Re: Objection to MP08_0244 MOD 1 Modification Request for Mixed Used Development at 23-37 Lindfield Avenue and 11 Havilah Lane, Lindfield

As a resident of Lindfield, I/we wish to lodge an objection against the proposed Modification of the subject development based on the following grounds:

Drawing Title
BASEMENT 1 PLAN

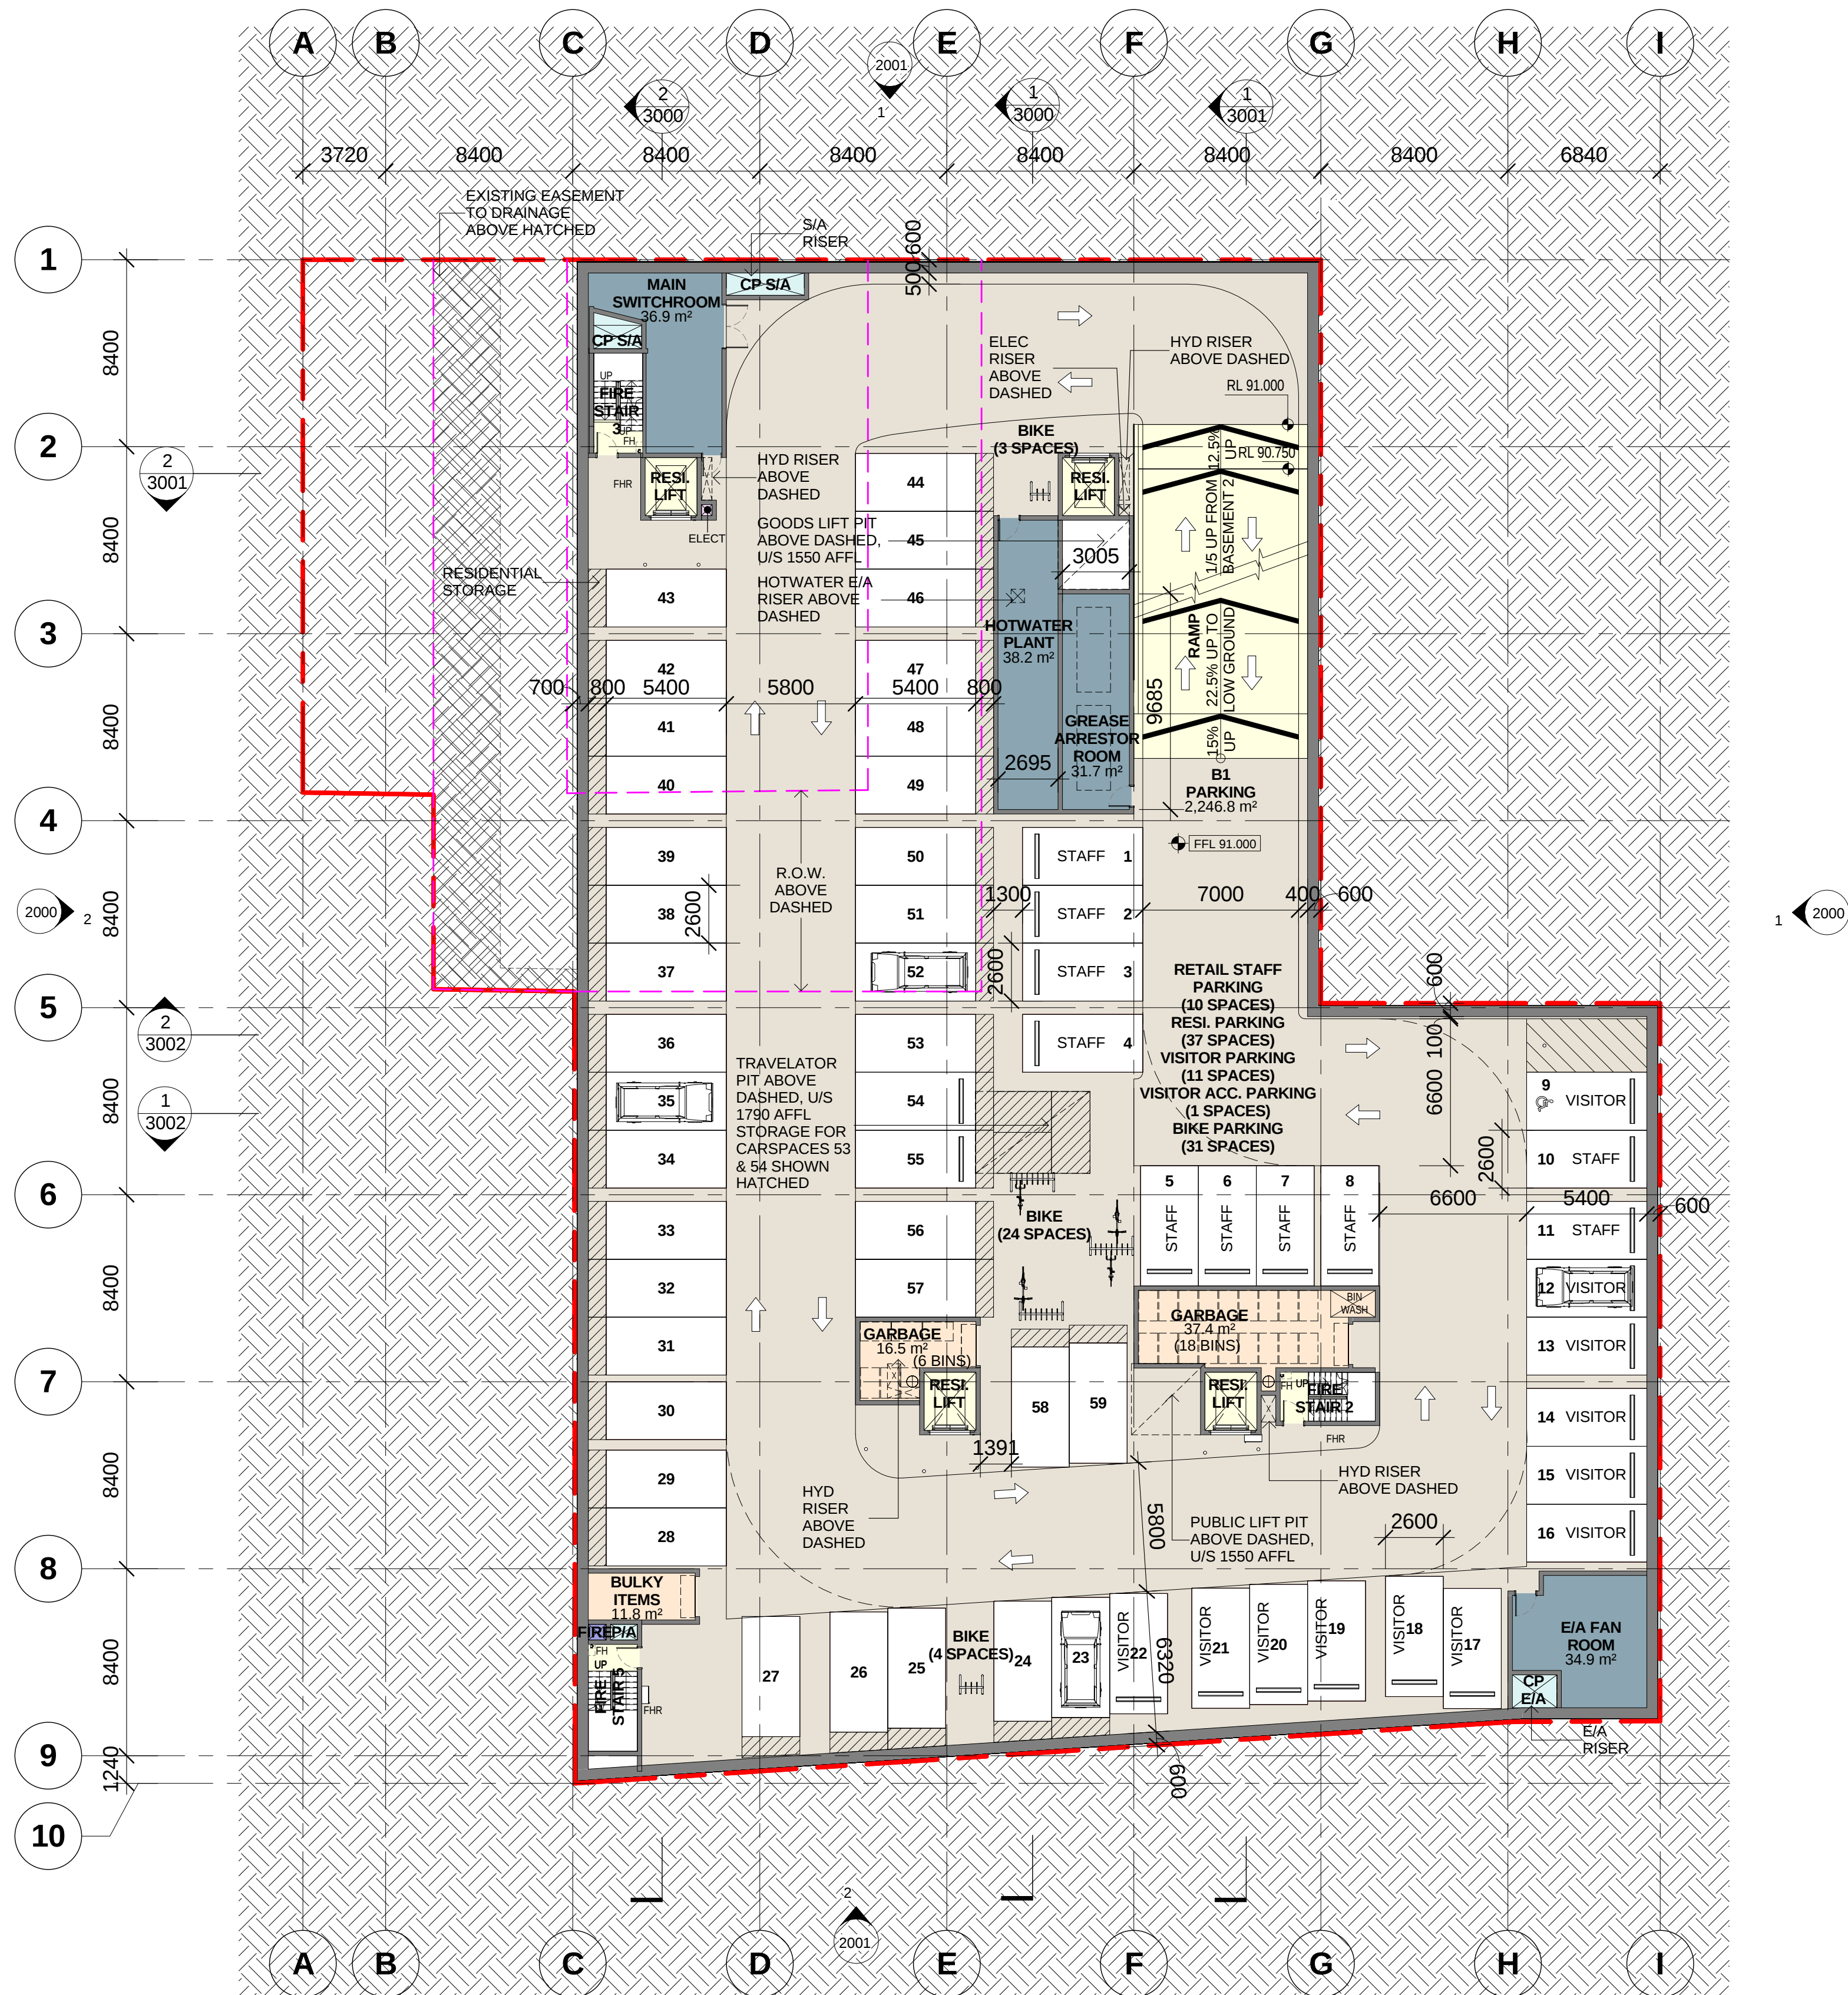
- Car spaces were identified as inadequate for the retail component and this has not been addressed relative to the remaining retail space proposed. The 25 car spaces counted as part of council's car park are also now highly uncertain due to the proposed rezoning and potential redevelopment.
